HYDRANT CONDITION CONSULTATION WITH PLANNING AUTHORITY

Planning Ref: WA/79/20/PL

Address: Spindlewood, Yapton Lane, Walberton, BN18 0AS

Description: Demolition of existing dwelling & erections of 8 No. new dwelling houses with associated landscaping & parking (resubmission following WA/30/20/PL). This application is a Departure from the Development Plan & is in CIL Zone 3 and is CIL Liable.

Drawing.
Proposed Site Plan

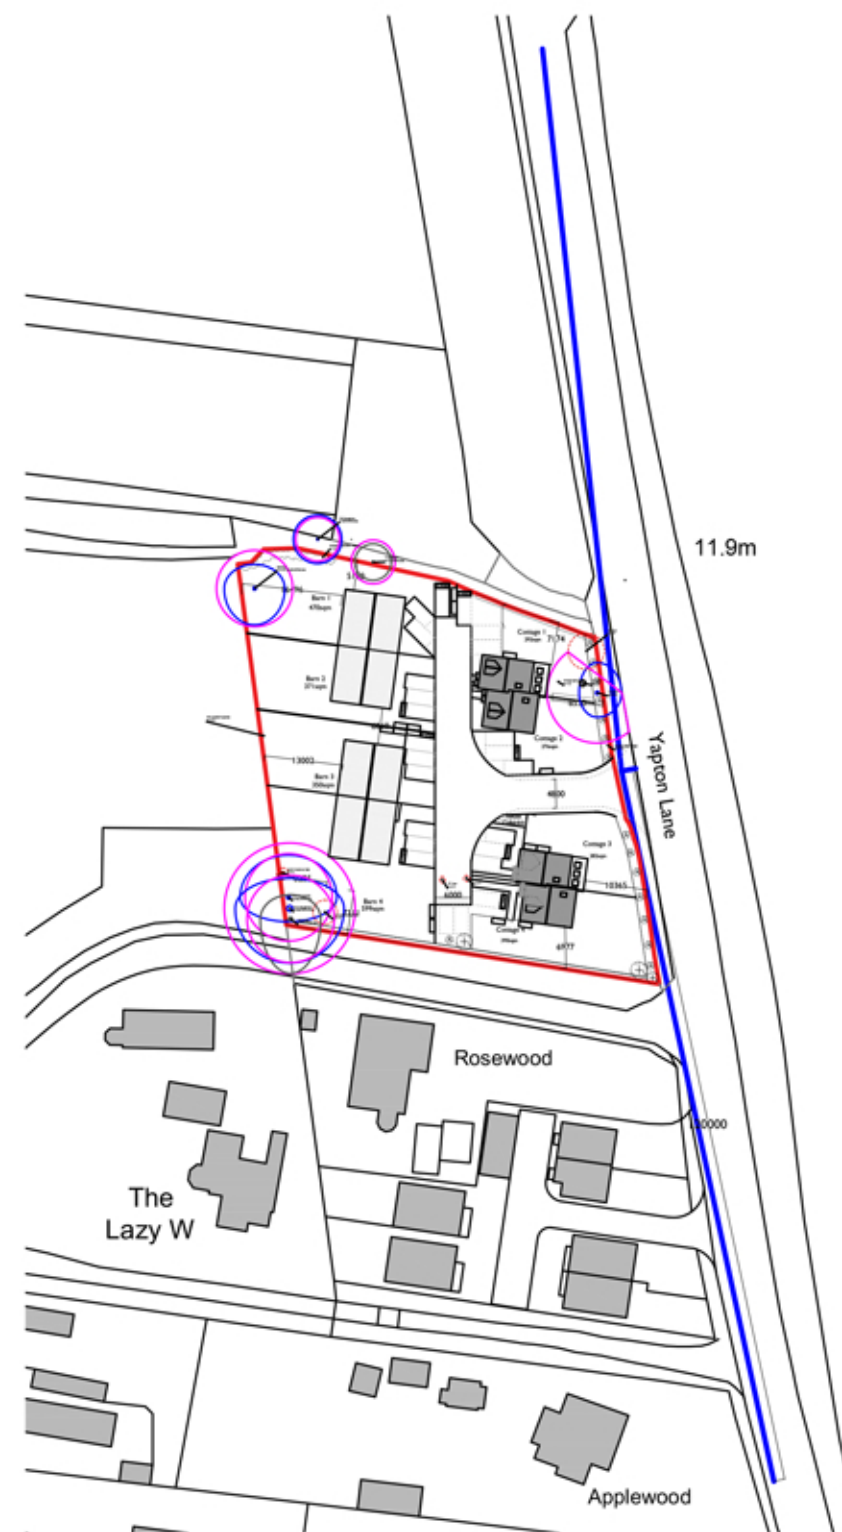
Please find attached a planning condition for application no. WA/79/20/PL for the requirement of an additional fire hydrant. Currently the nearest Hydrant to these proposed properties is 200 metres away. The supply of water for firefighting for a domestic premises should be within 175 metres.

- 1) Prior to the commencement of the development details showing the proposed location of [1] one fire hydrant or stored water supply (in accordance with the West Sussex Fire and Rescue Guidance Notes) shall be submitted to and approved in writing by the Local Planning Authority in consultation with West Sussex County Council's Fire and Rescue Service. These approvals shall not be unreasonably withheld or delayed.
- 2) Prior to the first occupation of any dwelling/unit forming part of the proposed development that they will at their own expense install the fire hydrant (or in a phased programme if a large development) in the approved location to BS 750 standards or stored water supply and arrange for their connection to a water supply which is appropriate in terms of both pressure and volume for the purposes of firefighting.
